10 June 2014

**Mannering Colliery – Section 75W Modification to MP06_0311 (MOD 2)
Chain Valley Colliery - Section 96 Modification to SSD-5465 (MOD 1)**

Proposed underground linkage
Manning Colliery – Modification 2
Figure 3.1

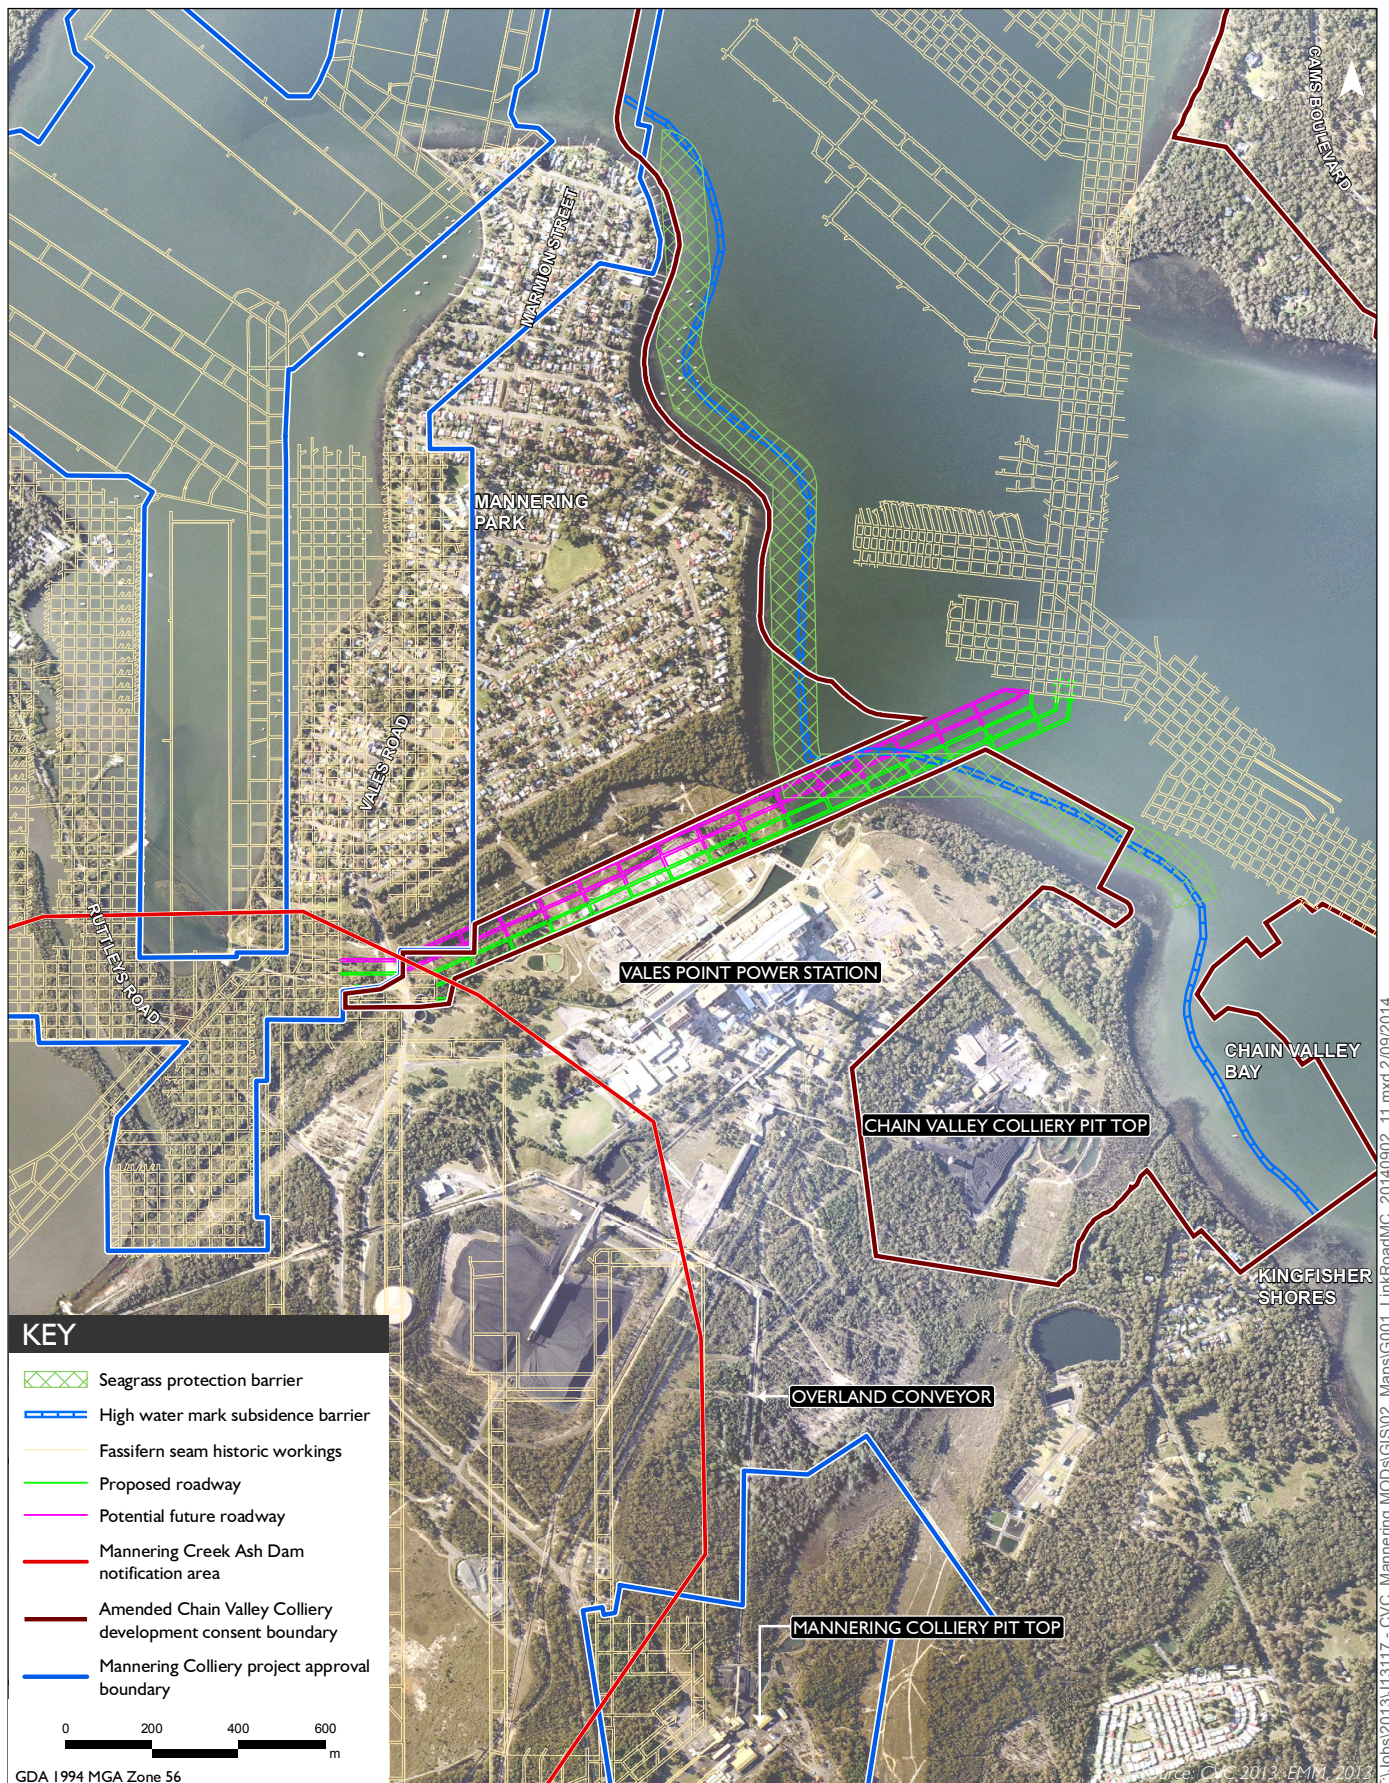
- It is unclear as to whether or not the proposed works would comply with existing conditions relating to subsidence (Schedule 3, Condition 4 for Mannering Colliery and Schedule 4, Condition 1 for Chain Valley Colliery). The proposed development should not result in any additional impacts to the natural environment caused by subsidence exceeding previously approved levels.

Client : EMGA
Job No/Name : MANNERING COLLIERY INTERSECTION Road Widths
Day/Date : Friday / 4th July 2014

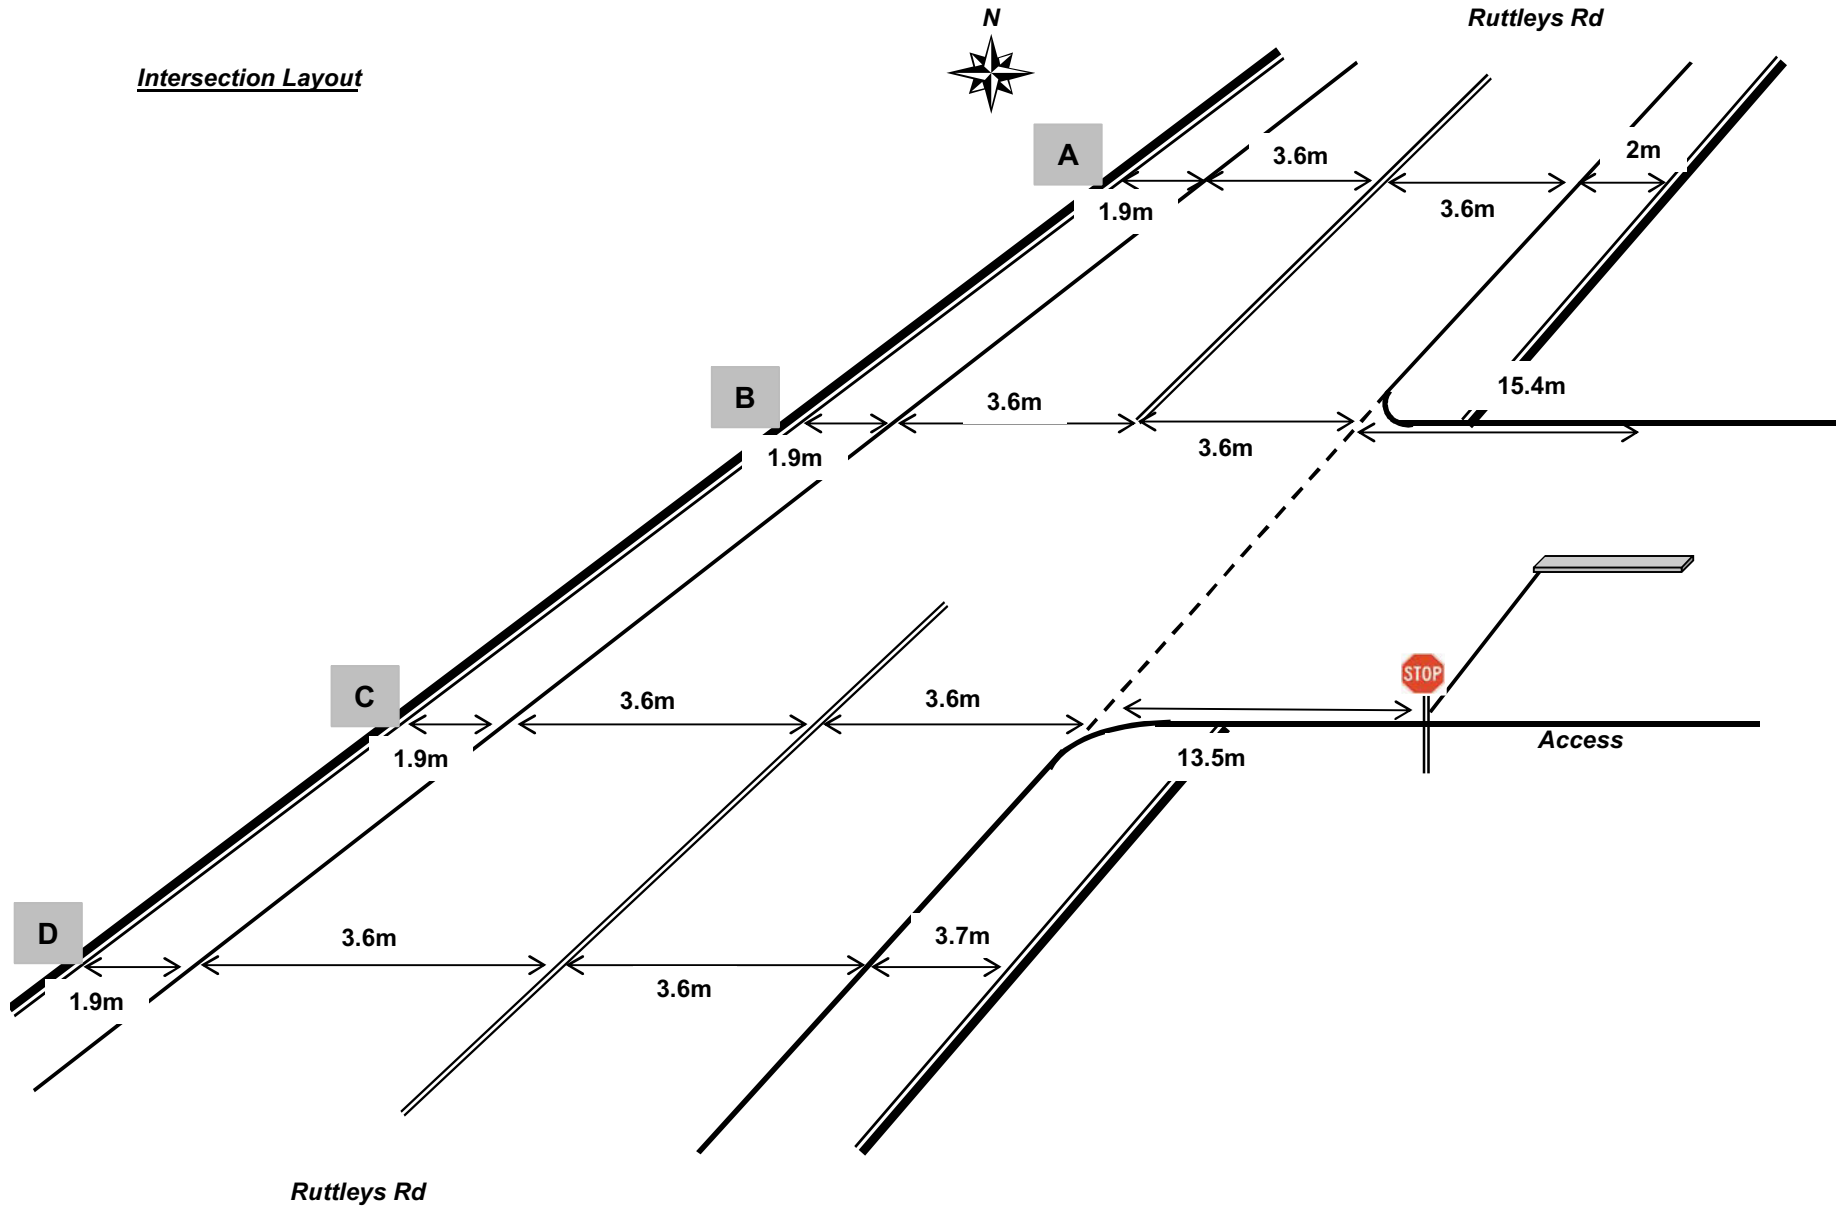
- It is noted that the 'Review of Ruttleys Road Intersection Upgrade Commitments' contained in Appendix D of the Environmental Assessment states that the recommendations of the road safety audit have been satisfactorily completed, although Council disagrees with this statement, particularly in relation to Item 7. Item 7 requires the reconstruction/repair of the shoulders on the approaches and departures to the intersection of Ruttleys Road/Access Road to allow vehicles to pass the intersection within the carriageway. The resurfacing that has occurred in this location comprises only a thin pavement for errant cars to regain control, not to pan right turning traffic. The existing pavement conditions do not provide diversion around right turning traffic and it this should be rectified prior to the recommencement of operations at Mannering Colliery.
